# Cummeennabuddoge Wind Farm

Technical Note - Habitat Review

FuturEnergy Ireland

March 2024

Figure 8-2
Habitats mapping
Map 3

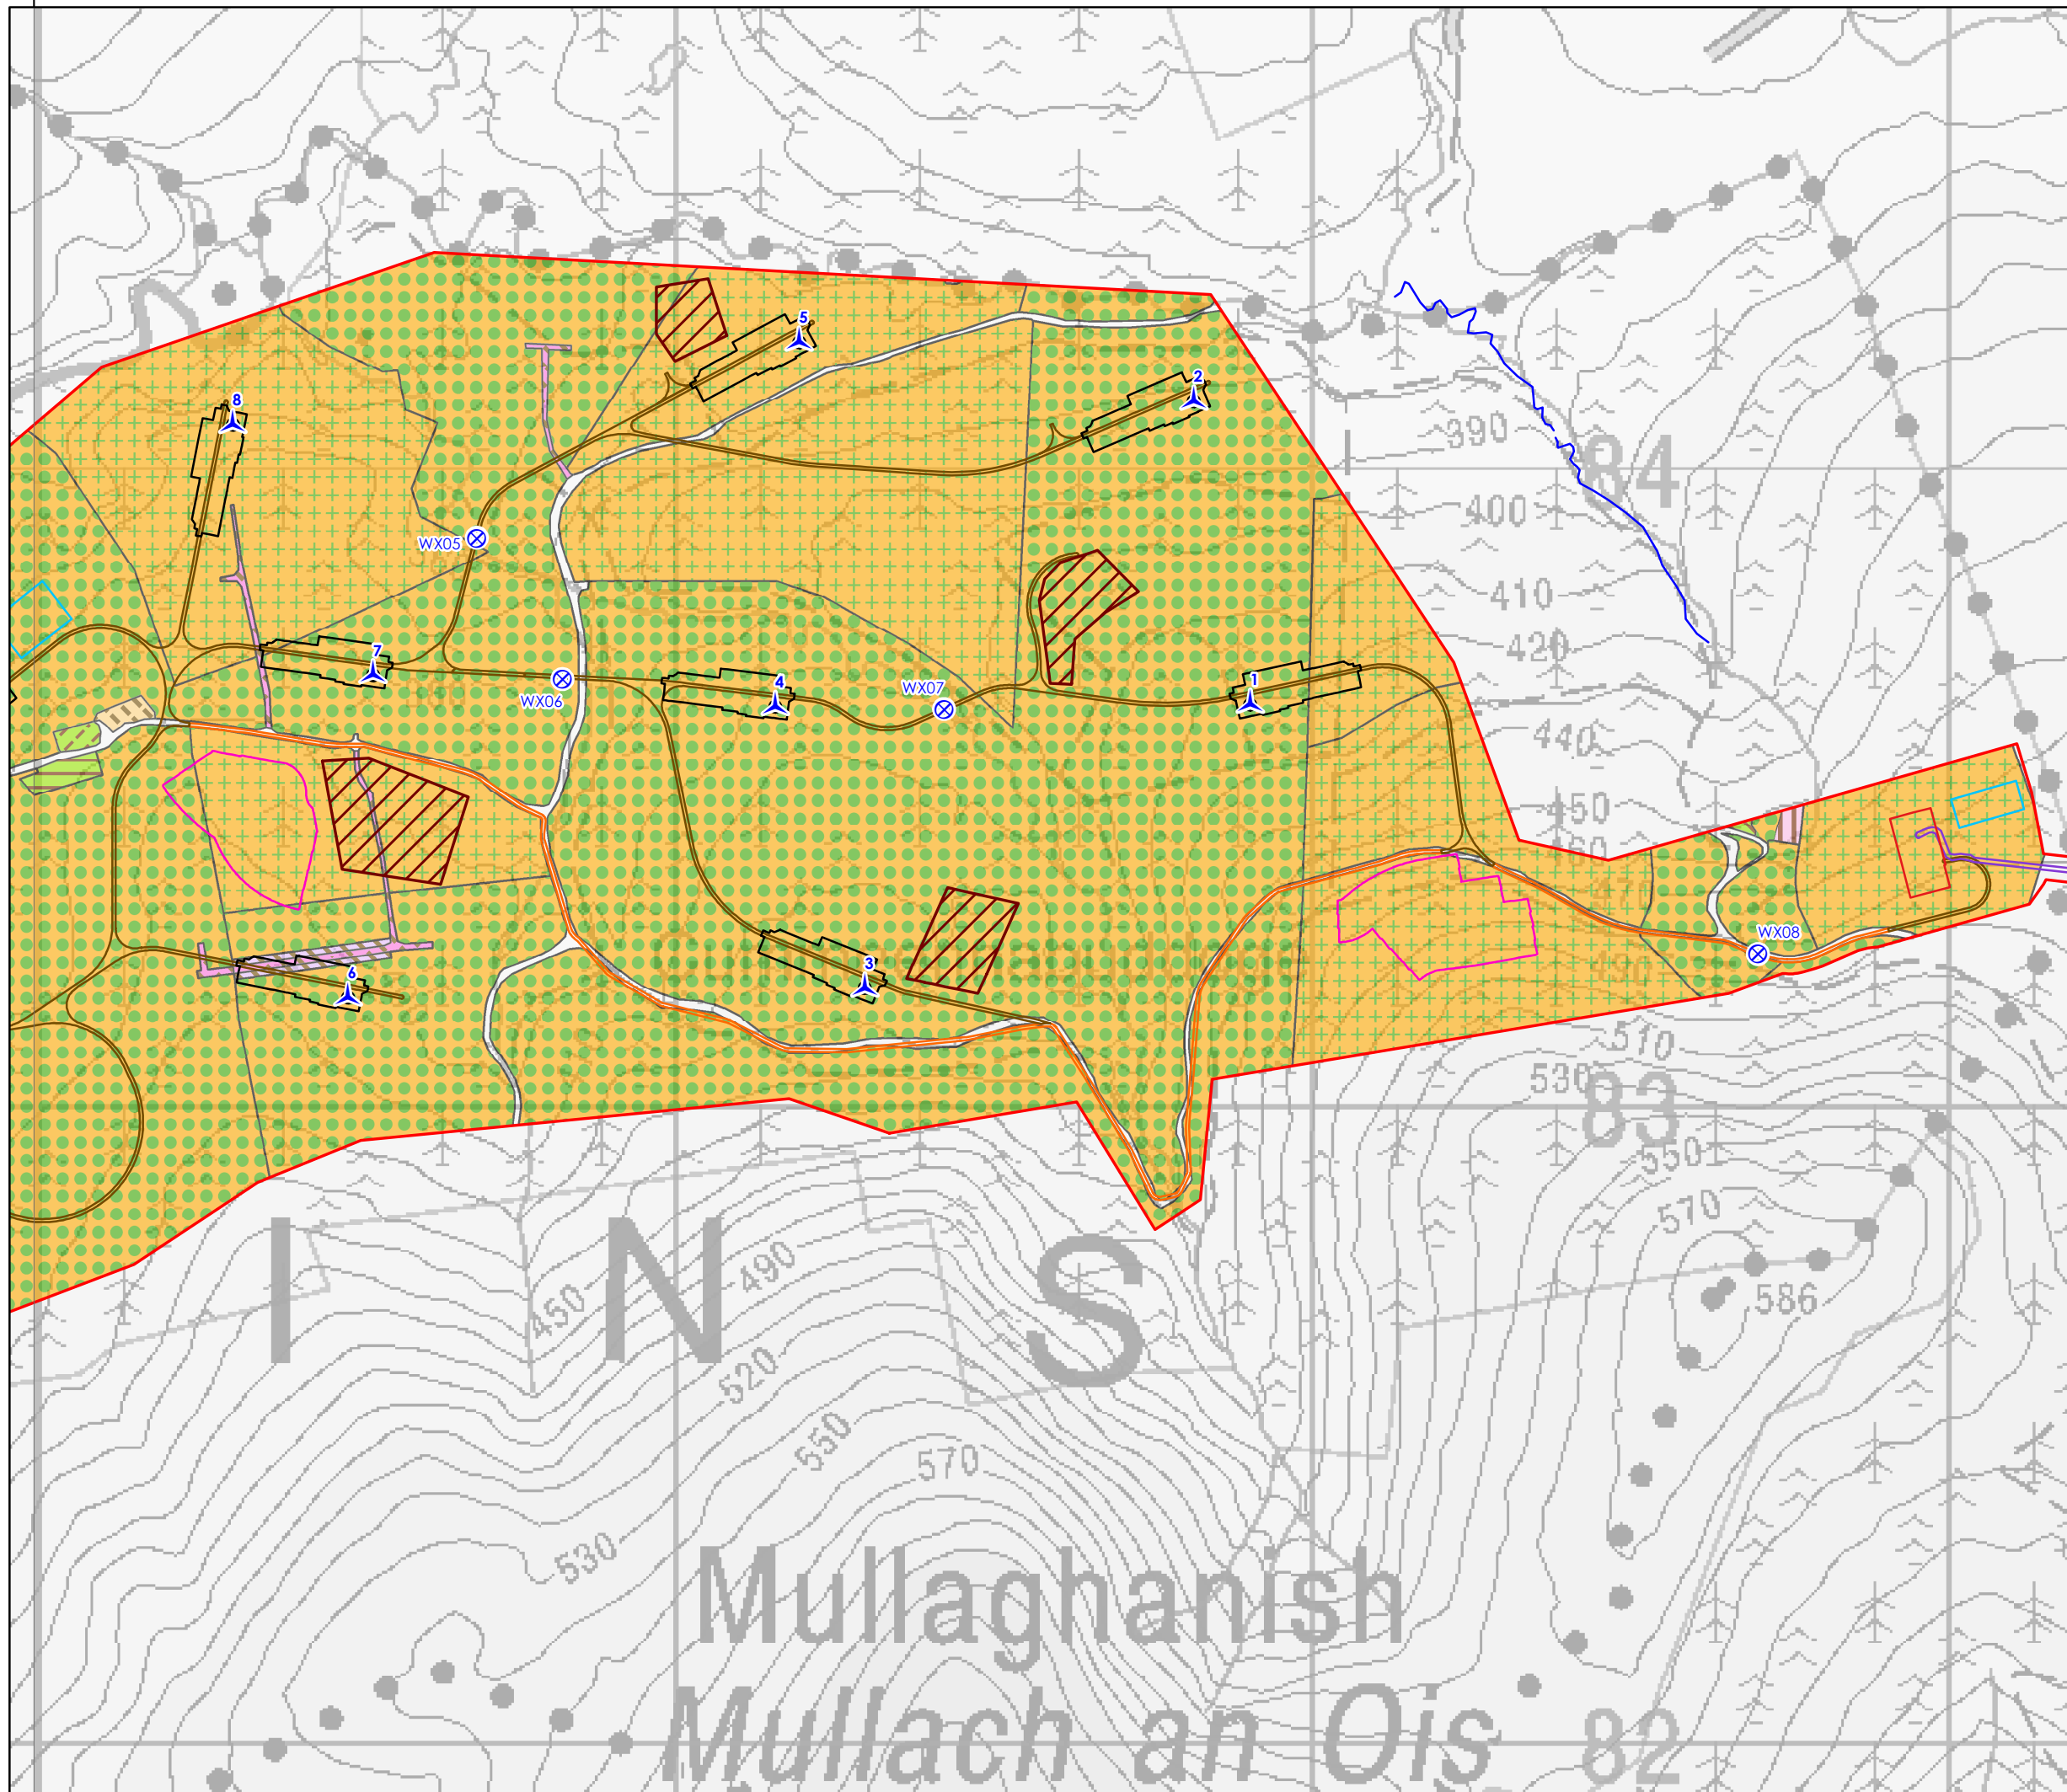
### 3.3 Sheet 3 – Eastern part of proposed turbine layout

This zone remains especially dominated by conifer plantation with very little other habitat. Zones marked as WS5 clear-fell in the previous habitat mapping are all now **WS2** recent conifer plantation, there is a new zone of **WS2** recent conifer plantation just west of proposed Turbine 6 (where the existing access track has also been extended), and the majority of other plantation in this area is now also **WS2** recent conifer plantation. Retained mature **WD3** mature conifer plantation is now restricted mainly to areas between proposed Turbines 5 and 8, around proposed Turbines 3 and 4, and in the vicinity of water crossing WX08.

There is a new zone of **WS2** recent broadleaved plantation (of willow *Salix* sp.) shortly east of proposed Turbine 2.

There is an active borrow pit corresponding to **ED4** active quarries south-east of proposed Turbine 10, with adjacent disturbed partially-vegetated spoil **ED2/3** (as previously mapped). The previous habitat mapping included an adjacent patch of disturbed ground in mosaic with marshy vegetation, however this is now considered a mix of **GS4** wet grassland (soft rush with acid pleurocarpous mosses) and **PF2** poor fen (soft rush with *Polytrichum commune* and sphagnum); there is also a channel of water here with bog pondweed *Potamogeton polygonifolius*.

The stream crossed by water crossing WX08 has open vegetation on the adjacent slopes which was largely not mapped in the previous survey, but includes limited extents of both **HH3** wet heath and **HH1** dry heath. Approximately 450 m south-east of proposed Turbine 3, and also unmapped previously, there is a narrow riparian zone of open vegetation similar to that described above (with **GS3** humid (acid) grassland and **PF2** poor fen/flush), and adjacent to the existing track here there is a narrow strip of **HH3** wet heath and (on the very steep cutting) damp **HH1** dry heath.

Figure 8-2
Habitats mapping
Map 4

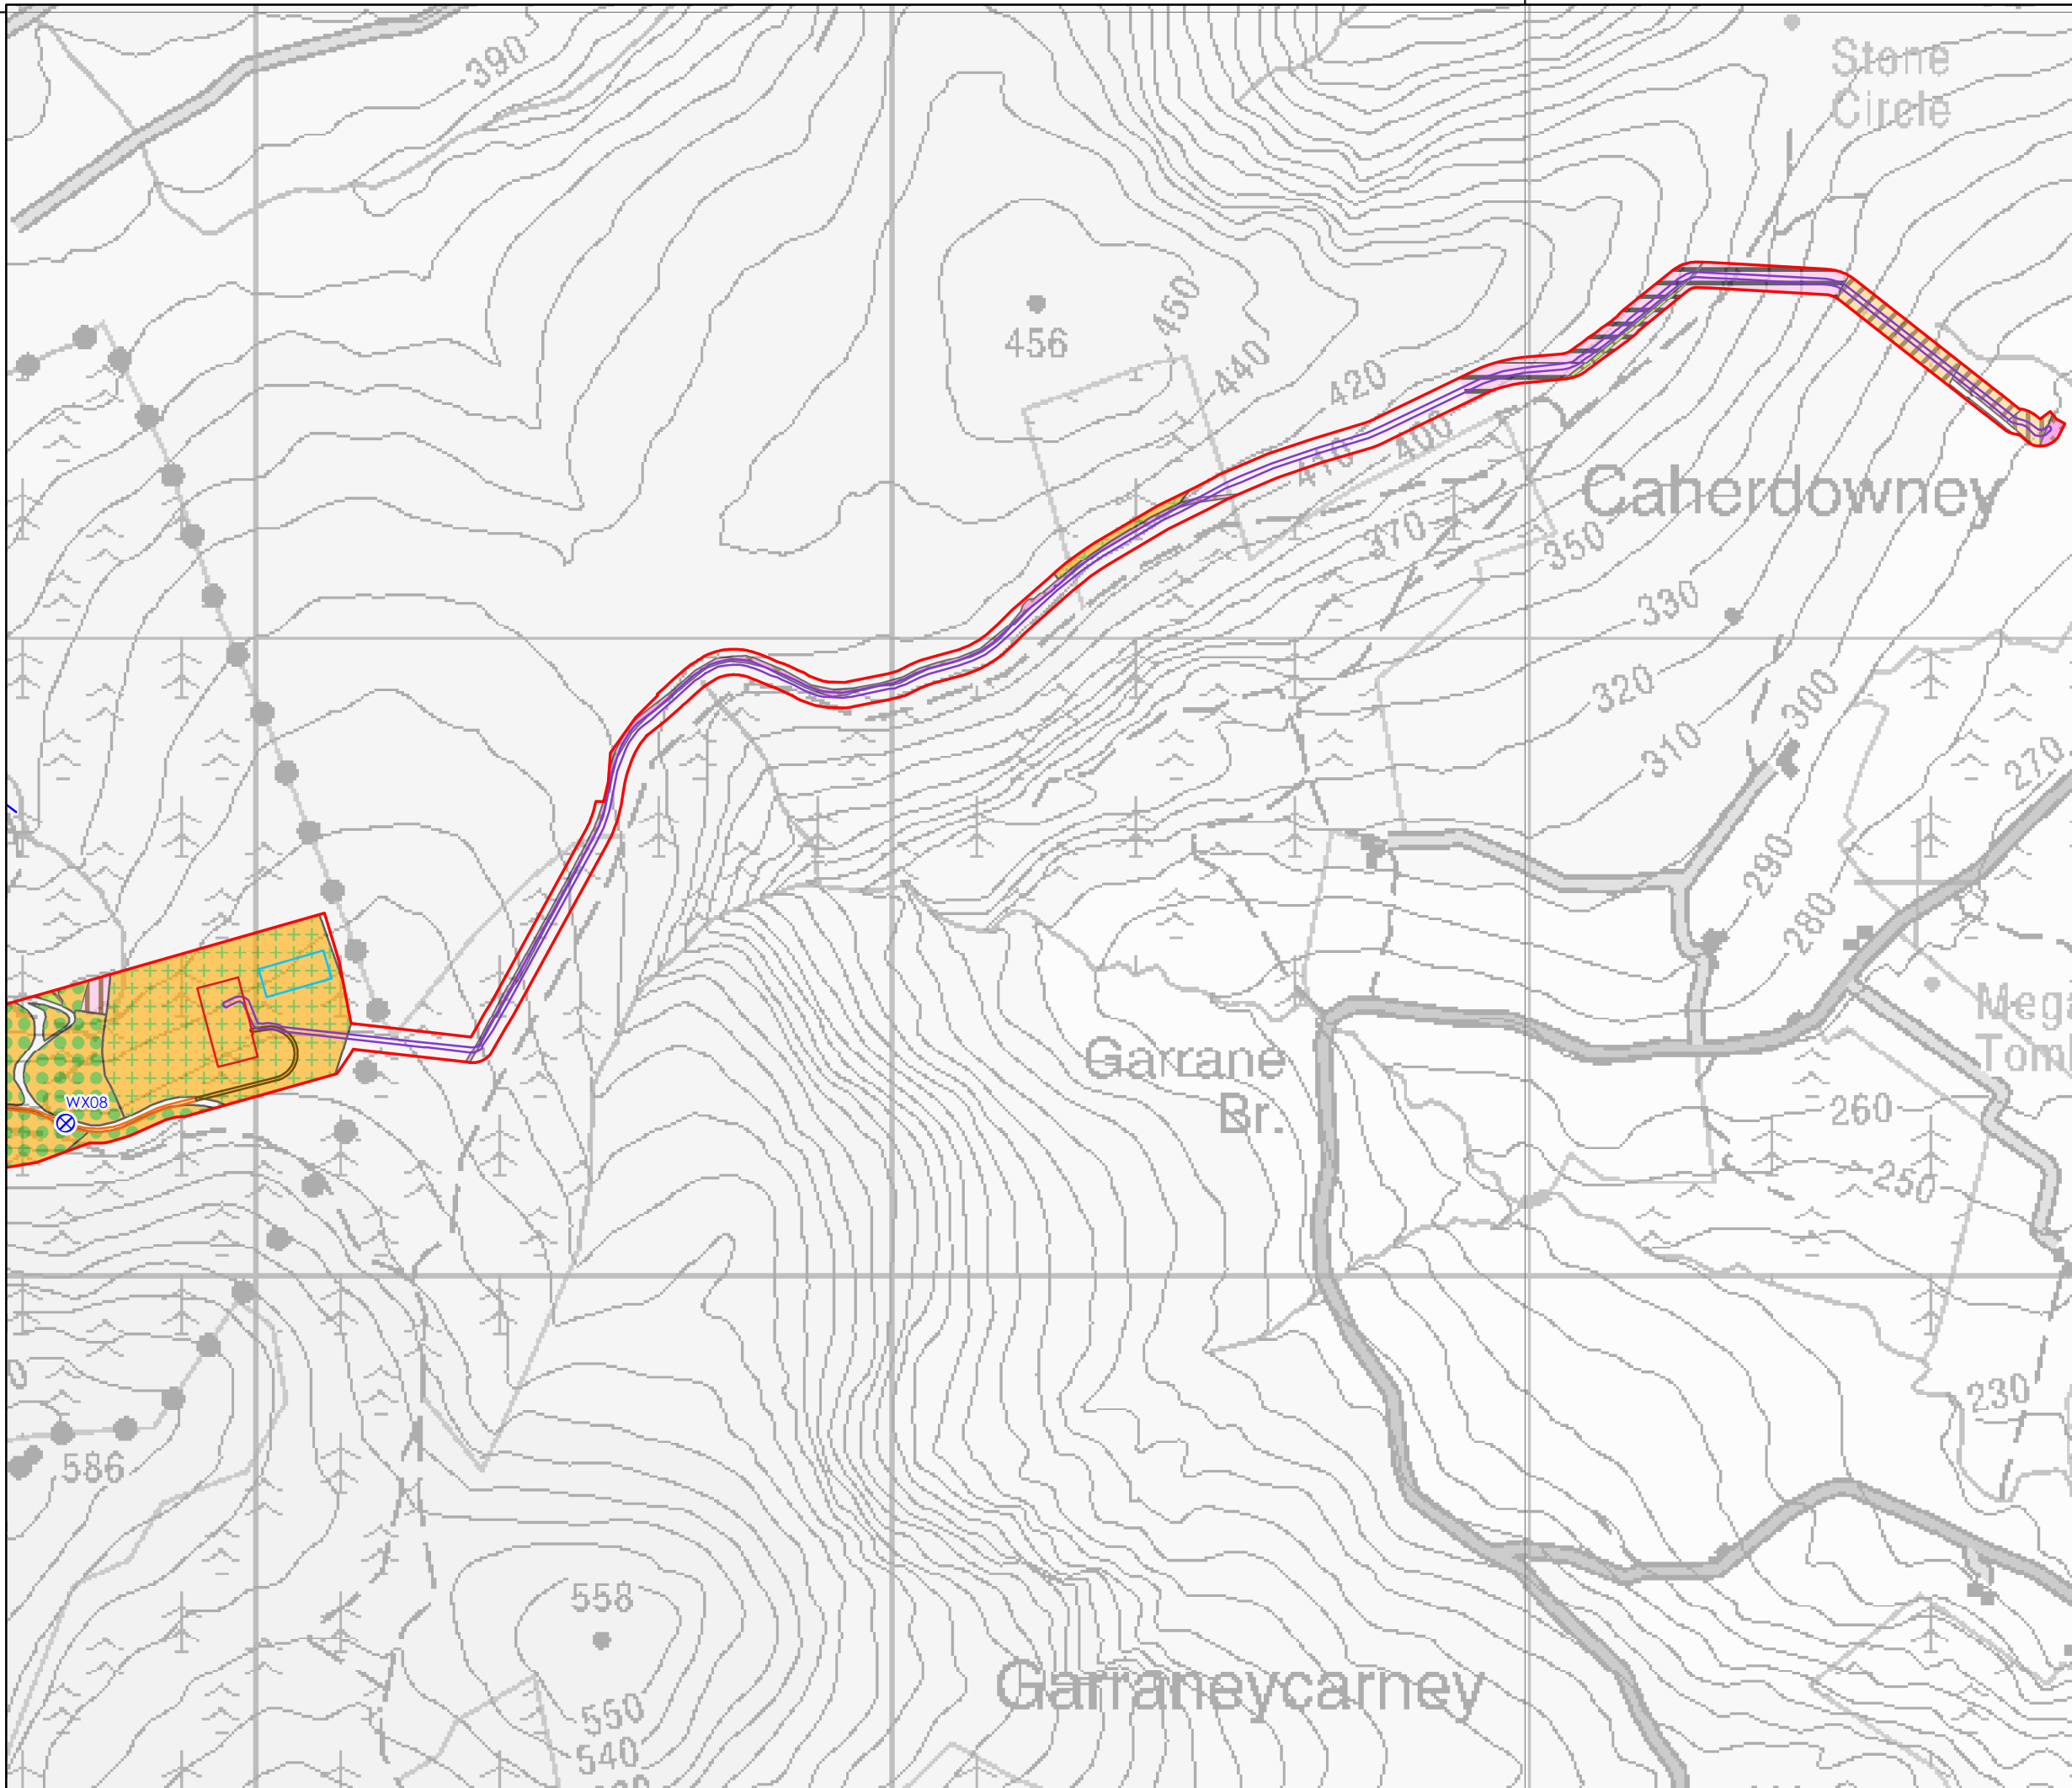
### 3.4 Sheet 4 – Grid connection

Only a very narrow strip of habitat was previously mapped along much of the grid connection.

On the south side of the existing access track, as far east as the hairpin bend, habitat within 100 m is either **WS2** recent conifer plantation or (more locally) **WD3** mature conifer plantation. East, of the hairpin bend in the existing access track, the sloping hillside supports extensive **HH3** wet heath (including within the previously-mapped narrow strip), until reaching agricultural fields beside the substation.

On the north side of the existing access track, there is some initial **WD3** mature conifer plantation, and then a long stretch (divided by two new access tracks for the existing wind farm) of **PB4** cutover bog with obvious peat cuttings (in places down to bedrock). Following a rectangular block of **WS2** recent conifer plantation, there is then mainly **HH3** wet heath, although just to the east of the rectangular plantation there appears to be some further **PB4** cutover bog, judging from visible raised peat hags.

As noted in the limitations above, the agricultural field beside the substation that the grid connection finally passes through was not closely inspected owing to uncertainty over access, and was viewed only from a distance. However, whilst the previous survey mapped this as **GS2** dry meadow, it seems likely that it is now **GA1** improved agricultural grassland, given how very short-grazed and even the sward appears, with in places thinly scattered soft rush. Whether or not closer inspection later in the year confirms this, it certainly appears from the intensity of grazing that that this grassland is likely to be in poorer condition than it was during the original survey.
